Arun District Council
Arun Civic Centre
Maltravers Road
Littlehampton
West Sussex BN17 5LF
Planning & Building Control General Enquiries
Tel: (01903) 737756 Fax: (01903) 730442
Dx: 57406 Littlehampton
Minicom: 01903 732765
e-mail: planning@arun.gov.uk
website: www.arun.gov.uk/planning

Application No: CM/17/21/PL
Site Address: Land at Wren Cottage Horsemere Green Lane Climping BN17 5QZ
Description of works: Development of 2 No. 2-bed & 2 No. 3-bed detached dwellings & associated works (resubmission following CM/53/20/PL). This site is in CIL Zone 3 & is CIL Liable as new dwellings.

Thank you for your internet representation made on 17th July 2021 which has been recorded as an objection with the comments as follows:

PLOT 1 FLOOR PLANS
SCALE 1:100 @ a3

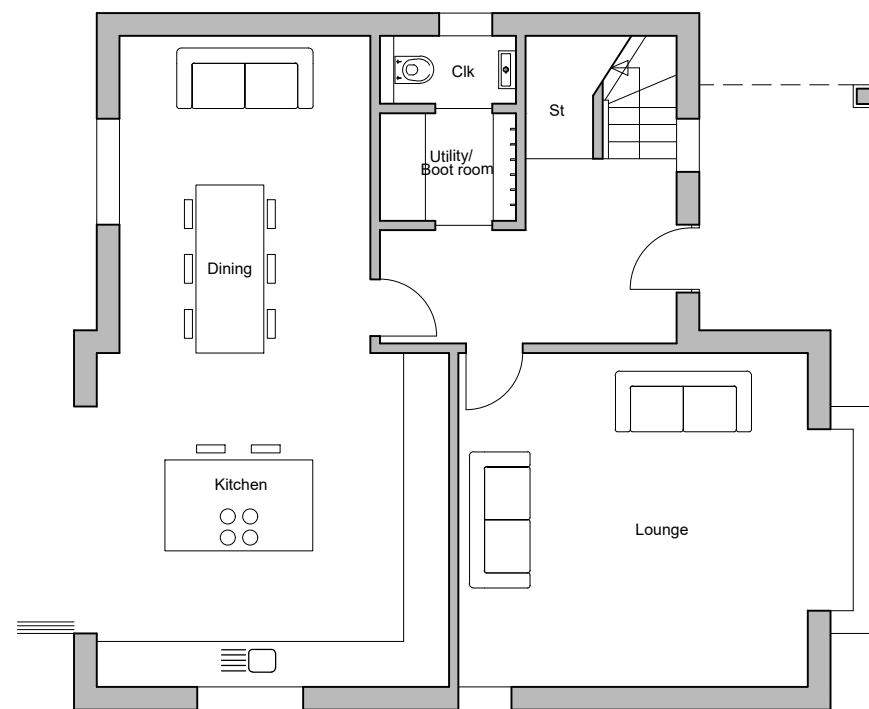
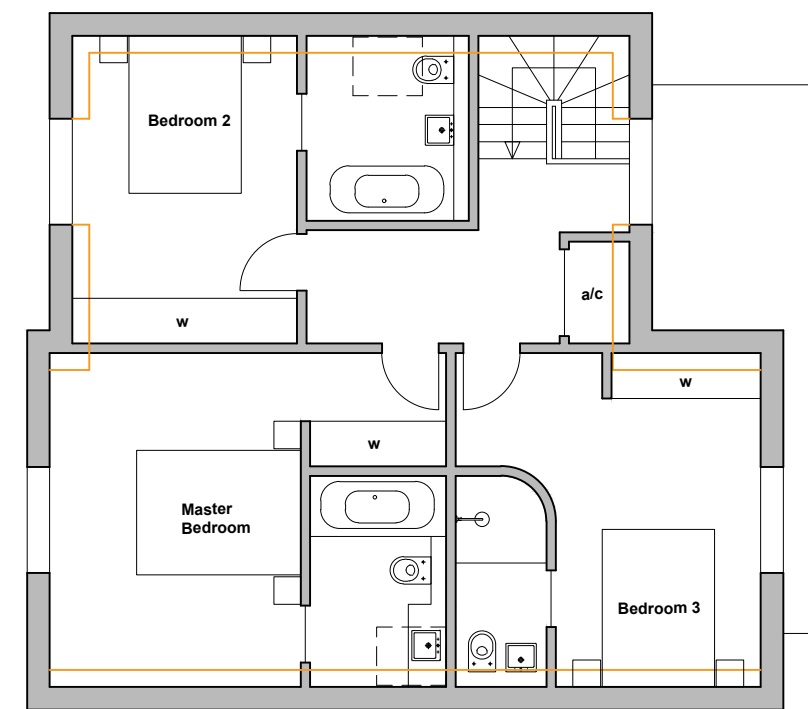
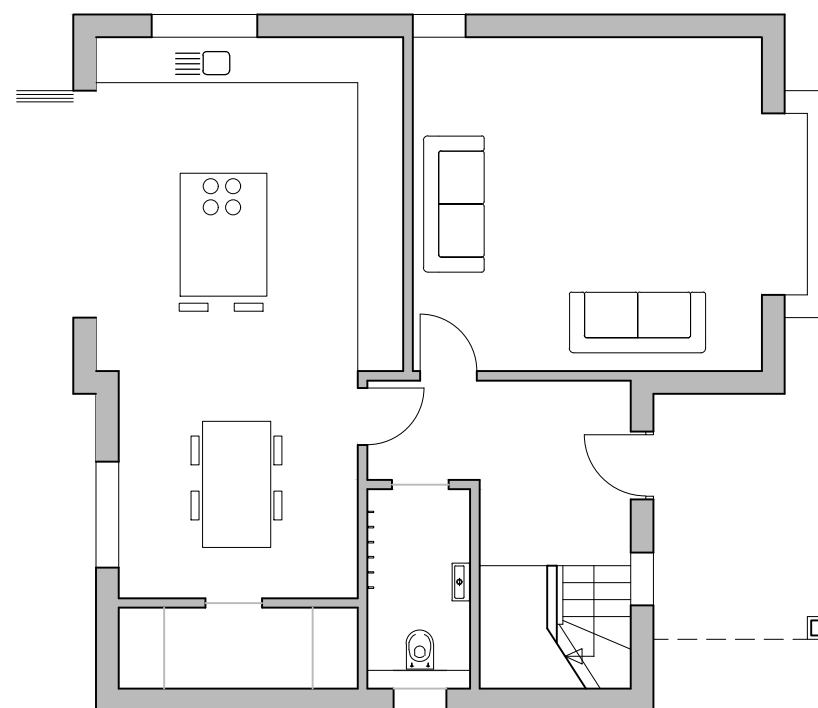
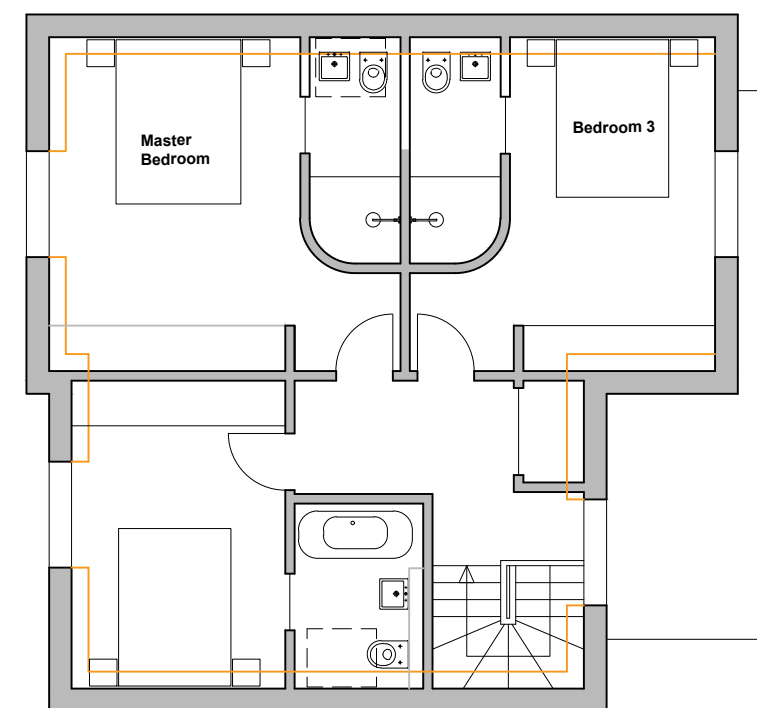
We are perplexed as to why plots 2 to 4 have had significant changes from the original plans all in favour of the residents of numbers 5 to 7 Wooldridge Walk but Plot 1 which overlooks and invades the privacy of 4 Wooldridge Walk has been left out in the cold and has had no changes to the original plans whatsoever.

Can you explain why it still remains a large 3 bedroom house with 2 bedrooms facing west each with double windows overlooking 4 Wooldridge Walk's garden and into its 2 back bedrooms.
